Ribble Valley Borough Council
By email

Your ref 3/2025/0652
Our ref DC/25/2452 v2
Date 10-NOV-25

Location: Hall Barns Farm Knowles Brow Hurst Green BB7 9PT
Proposal: Proposed extension to existing approved agricultural building.

UNITED UTILITIES WATER MAIN - REQUIREMENT FOR FURTHER INFORMATION

Drawing Title
 EXISTING SITE PLAN

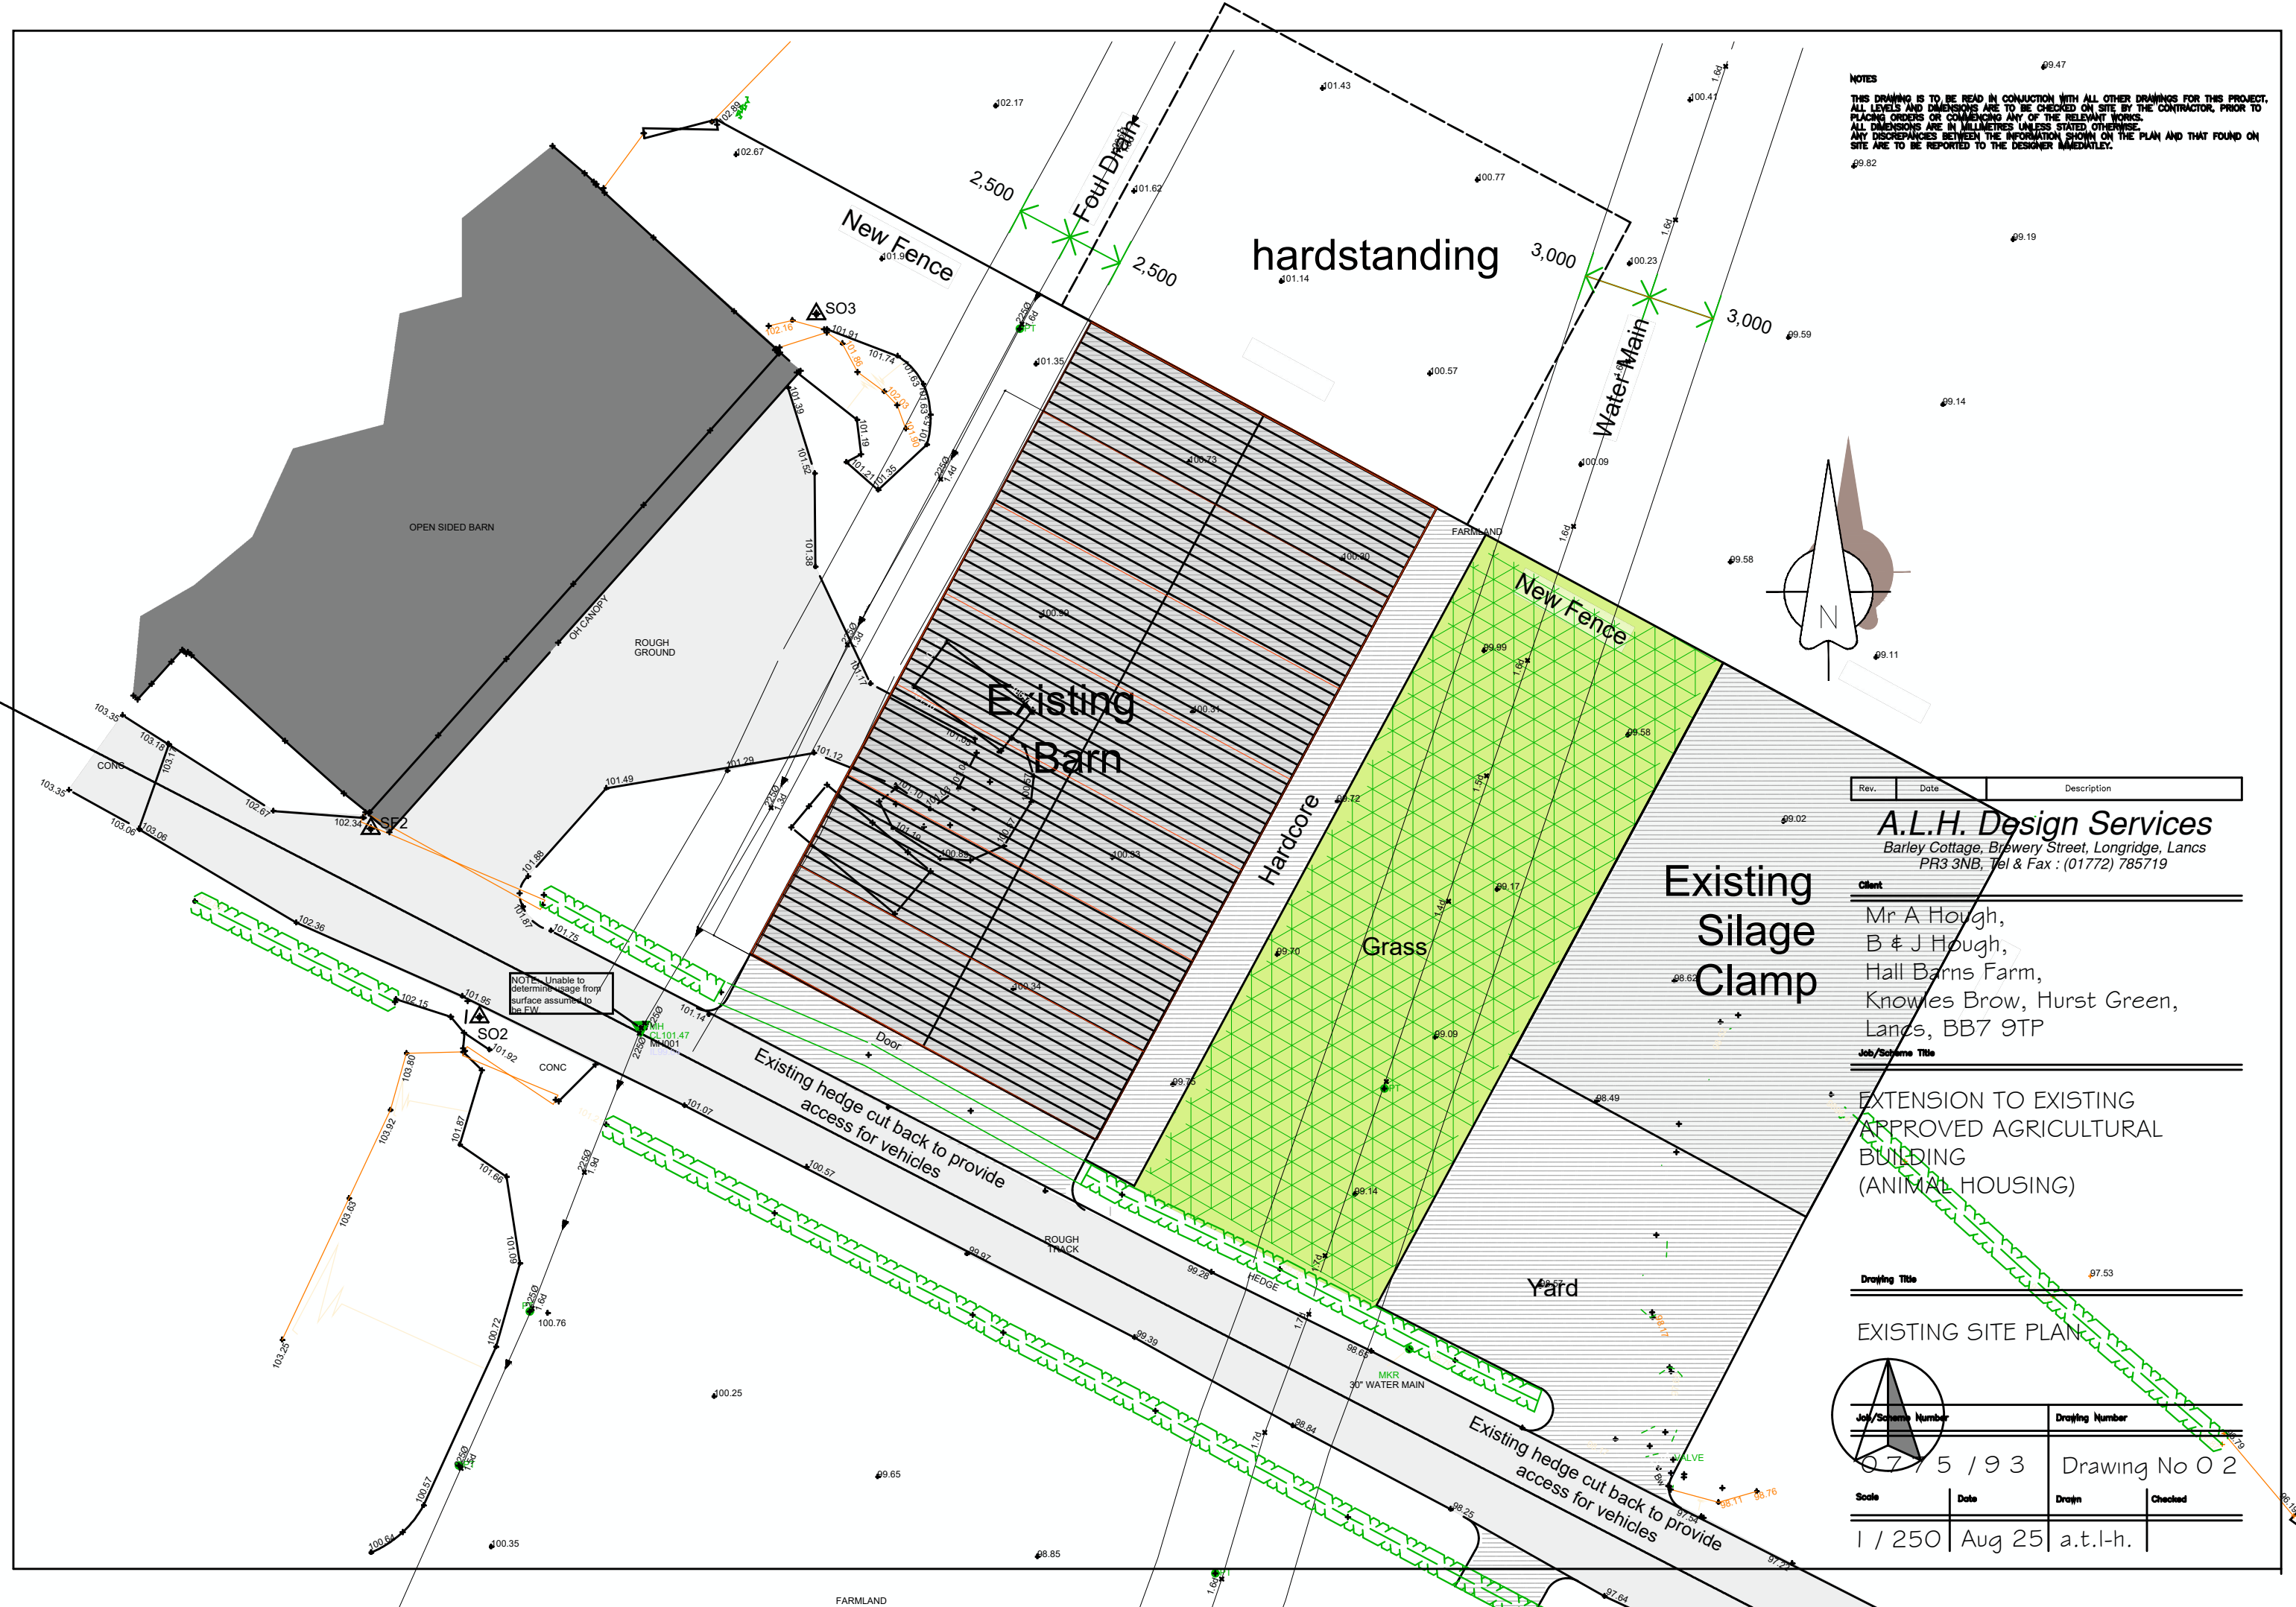
As noted in our first response on 28th October 2025, development is proposed close to, or potentially over, a United Utilities Water Main on east of the site. The applicant has acknowledged this in the amended site plan but has yet to provide any clarity, by way of agreement with United Utilities, on the **EXACT** location of the asset to ensure it will not be directly built over or within the dedicated easement.

The amended site plan has outlined a 6-metre easement for the pipeline. The required easement according to our standard conditions would be 10 metres. proposed development is potentially within the easement of the water main in question. It is important to understand that **we will not permit development over or in the easement** so agreements on the exact location must be agreed to ensure the extension can be delivered. Without resolution to the concerns prior to determination, our position must be to **OBJECT** to the application.
